From: Edward du Boulay [REDACTED]
Sent: 10 November 2025 10:34
To: Botley West Solar Farm
Cc: clerk; [REDACTED]@parliament.uk
Subject: Botley West: visual impact from [REDACTED]
Attachments: View from 2nd Floor Study.jpg; View from 1st Floor Bedroom.jpg; View from Front Doorstep.jpg

We wish to highlight that the Residential Visual Amenity Assessment (EN010147-002020-17.13) submitted by the Applicant grossly misrepresents factual reality in respect of our property.

**Illustrative Masterplan**  
**Figure 2.3**  
**Southern Site Area**

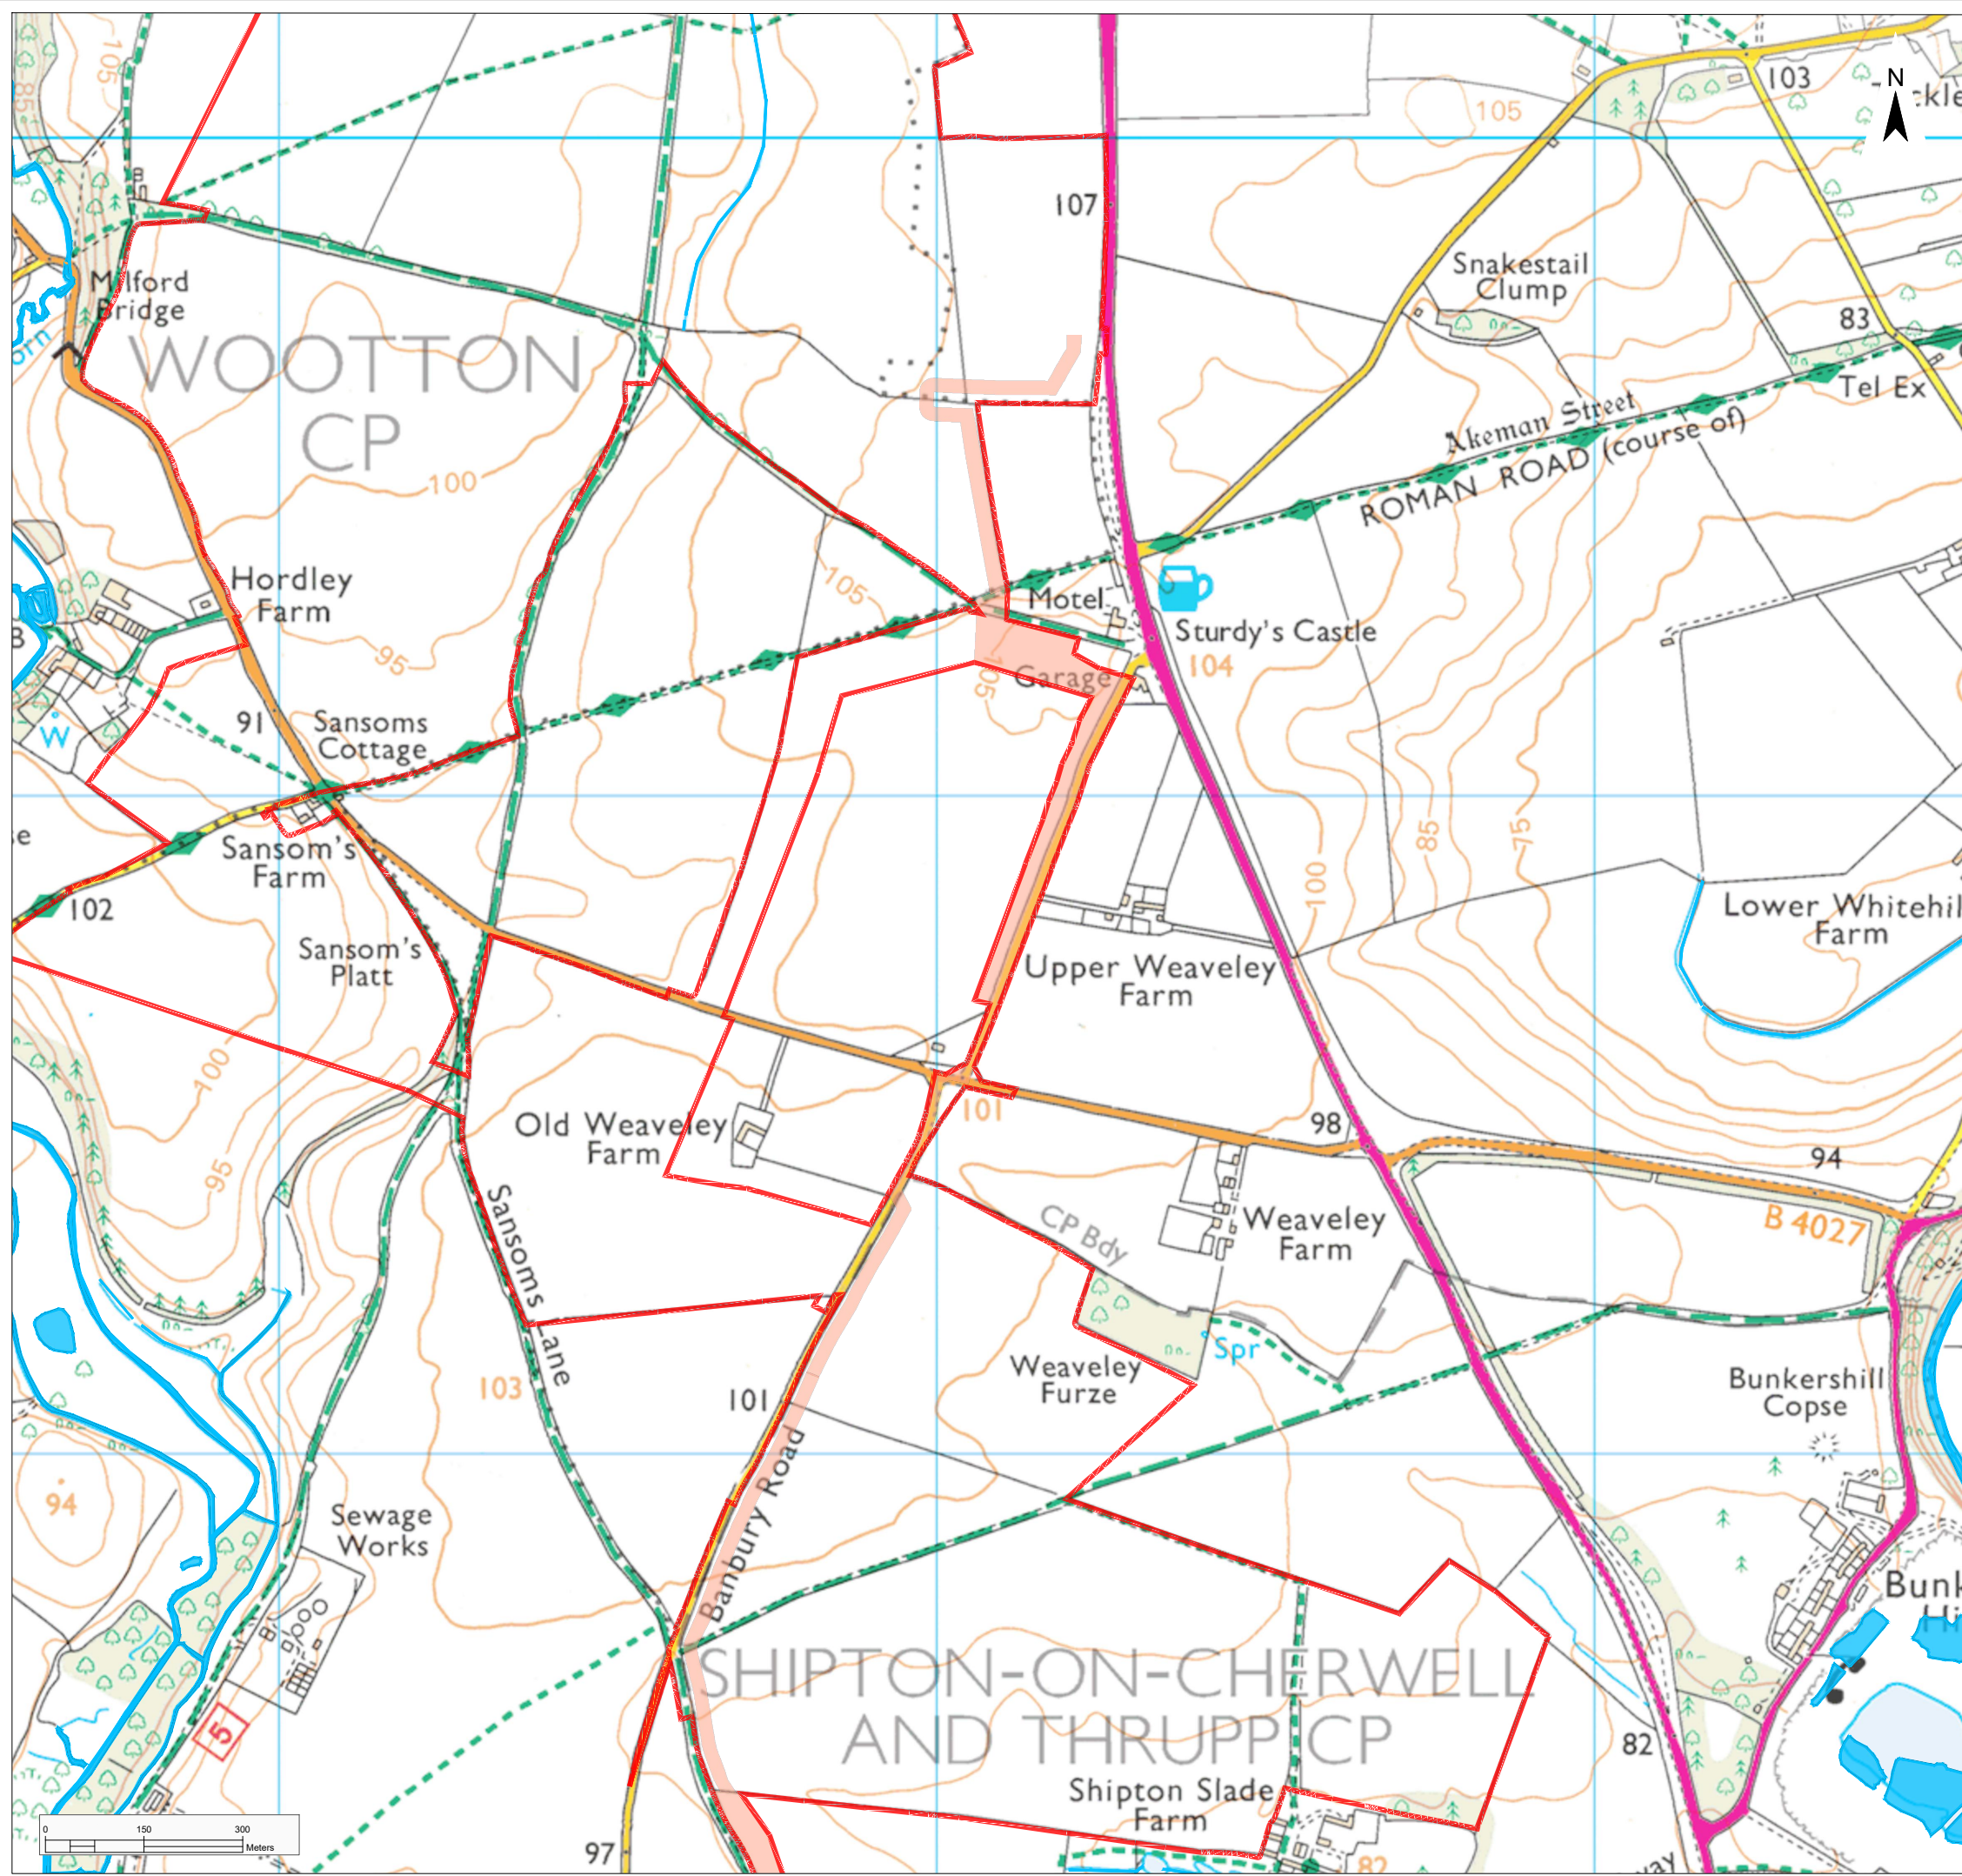
Our main concern is the substation, which would be prominently exposed to all parts of our house and front garden. It would be a significant mitigation if the substation were to be screened by extensive green foliage, but we have seen no meaningful suggestions from the Applicant in that regard.
